Date: 12 May 2015

Application by National Grid Gas plc for an Order Granting Development Consent for the River Humber Gas Pipeline Replacement Project

Section 51 advice

RIVER HUMBER GAS PIPELINE REPLACEMENT PROJECT		
INDICATIVE PAULL SITE LAYOUT FIGURE 2.4 B		
REFERENCE		
DRAWN	CHECKED	APPROVED
JN	KB	NH
SCALE	ORIG SIZE	SHEET
1 : 1000	A1	1 of 1
DATE		REVISION
12 OCT 15		03

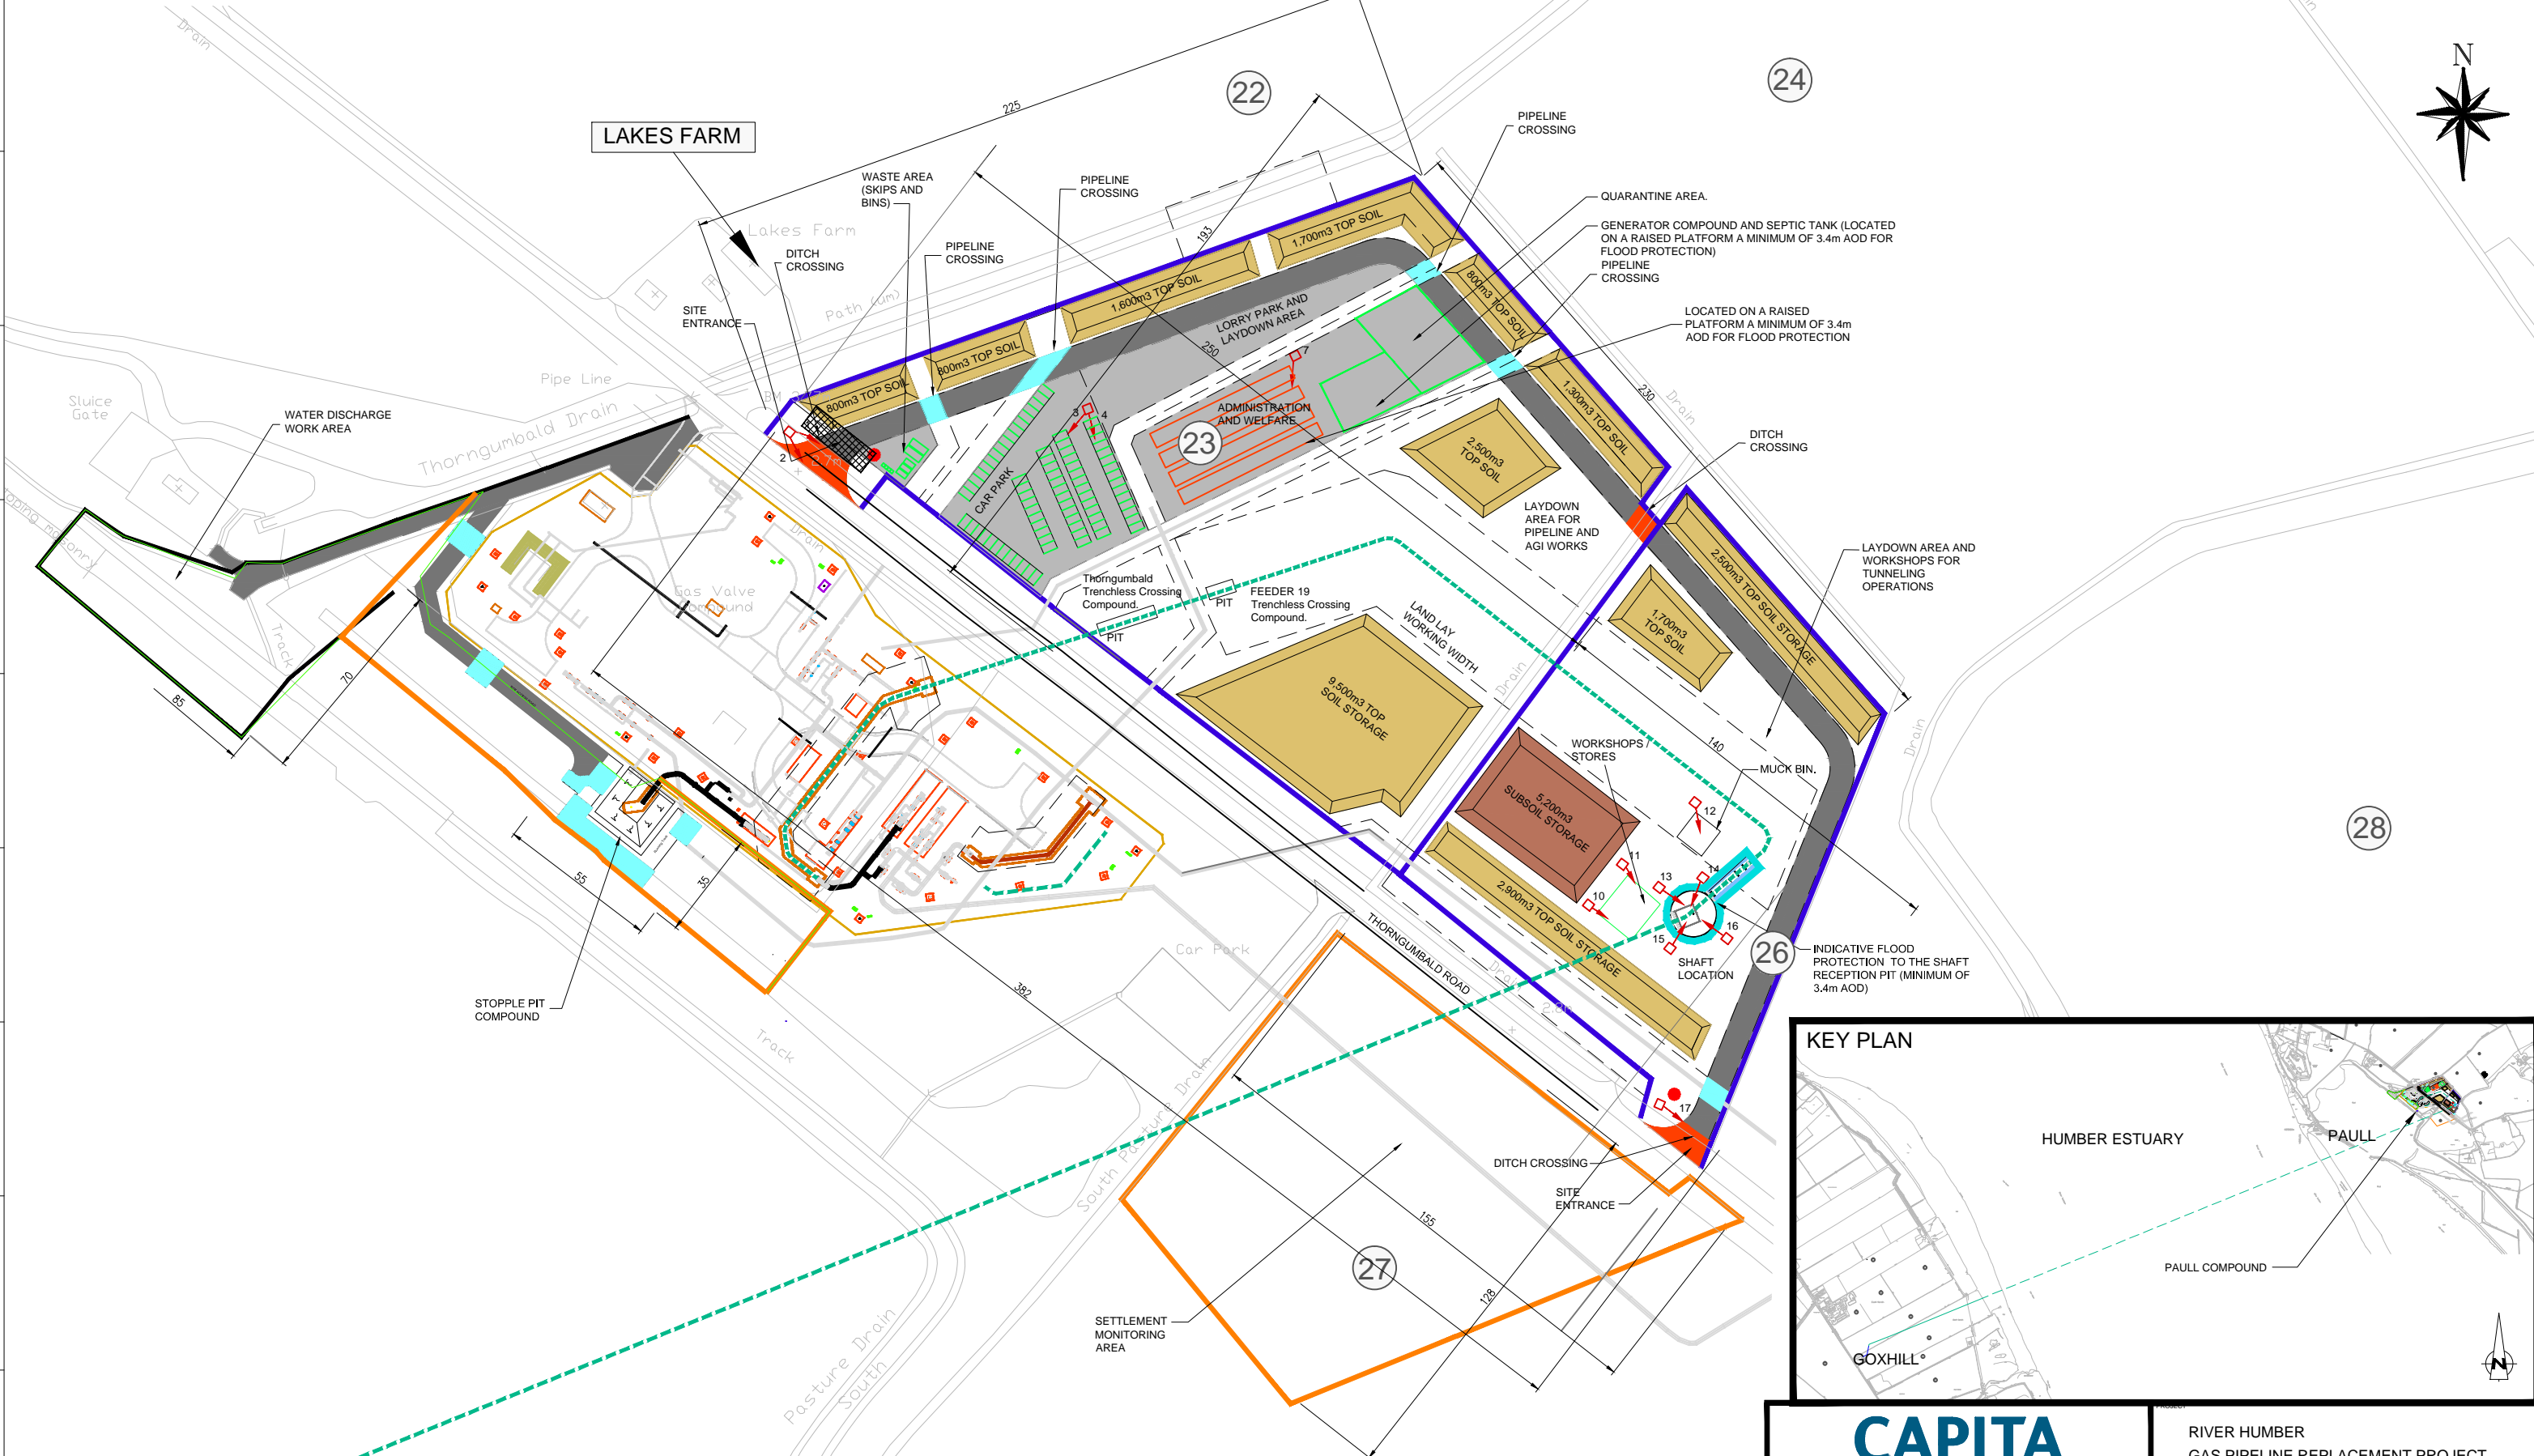
The dimension text on the Indicative Goxhill and Paull Site Layout plans, doc 2.4 are not legible when printed, it would be useful if this could be rectified.
